Application no: 22/02469/DISC

Location: OS Parcel 9507 South Of 26 And Adjoining Fewcott Road, Fritwell.

Transport Development Control

Drawing title  
 Construction Traffic  
 Management Plan

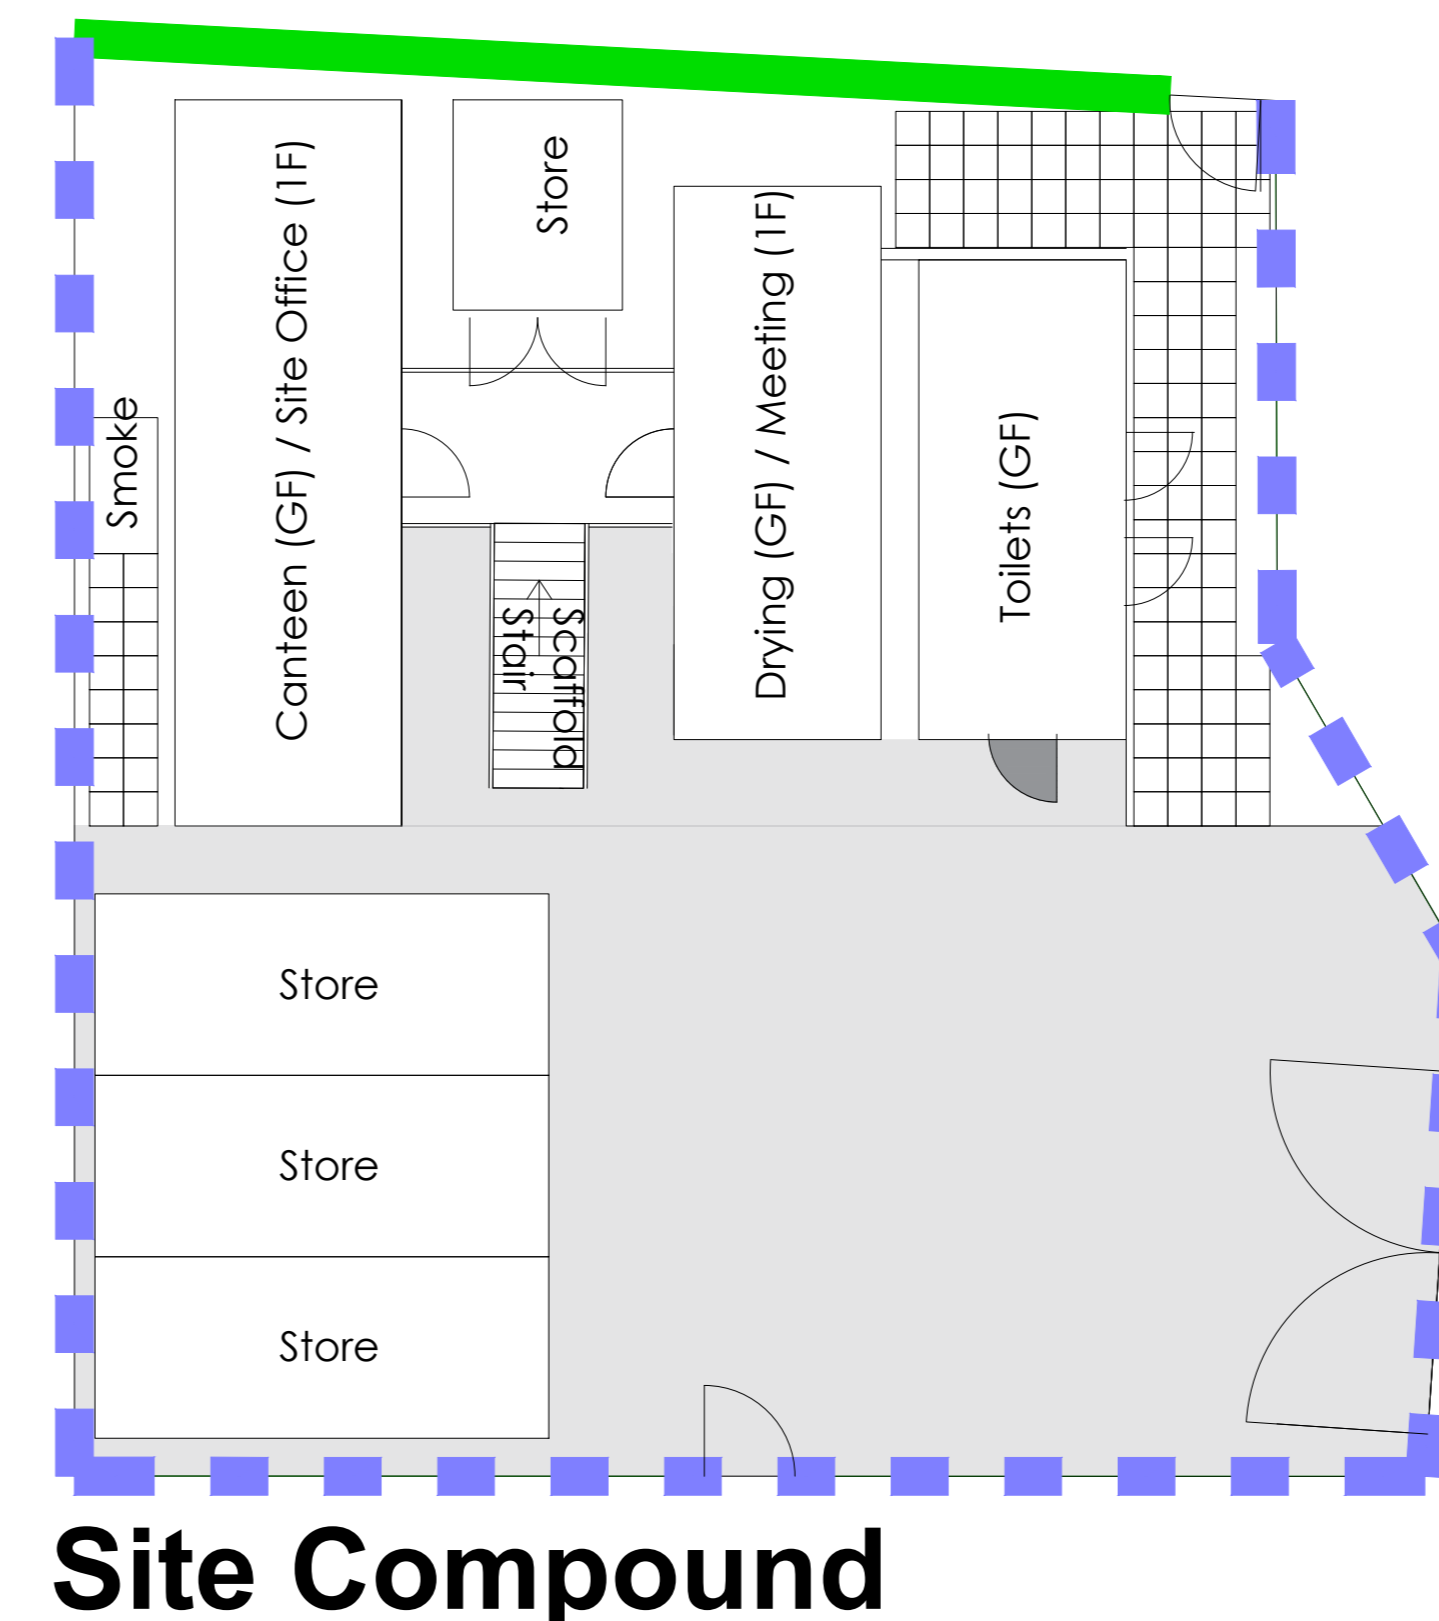
In order to discharge the CTMP, the following points must be addressed:

- The CTMP must be appropriately titled, include the site and **planning permission number**.
- Routing of construction traffic and delivery vehicles is required to be shown and signed appropriately to the necessary standards/requirements. This includes means of access into the site.

- Details of appropriate signing, to accord with the necessary standards/requirements, for pedestrians during construction works, including any footpath diversions.

- A regime to inspect and maintain all signing, barriers etc.
- Contact details of the Project Manager and Site Supervisor responsible for on-site works to be provided.

- The use of appropriately trained, qualified and certificated banksmen for guiding vehicles/unloading etc.
- Local residents to be kept informed of significant deliveries and liaised with through the project. Contact details for person to whom issues should be raised with in first instance to be provided and a record kept of these and subsequent resolution.

- Any temporary access arrangements to be agreed with and approved by Highways Depot.

- Details of times for construction traffic and delivery vehicles, which must be outside network peak and school peak hours.
- Deliveries must be avoided between 07:30-09:00, 15:00-15:30 and 16:30-18:00 to avoid school drop off/ pick up and network peak hours.
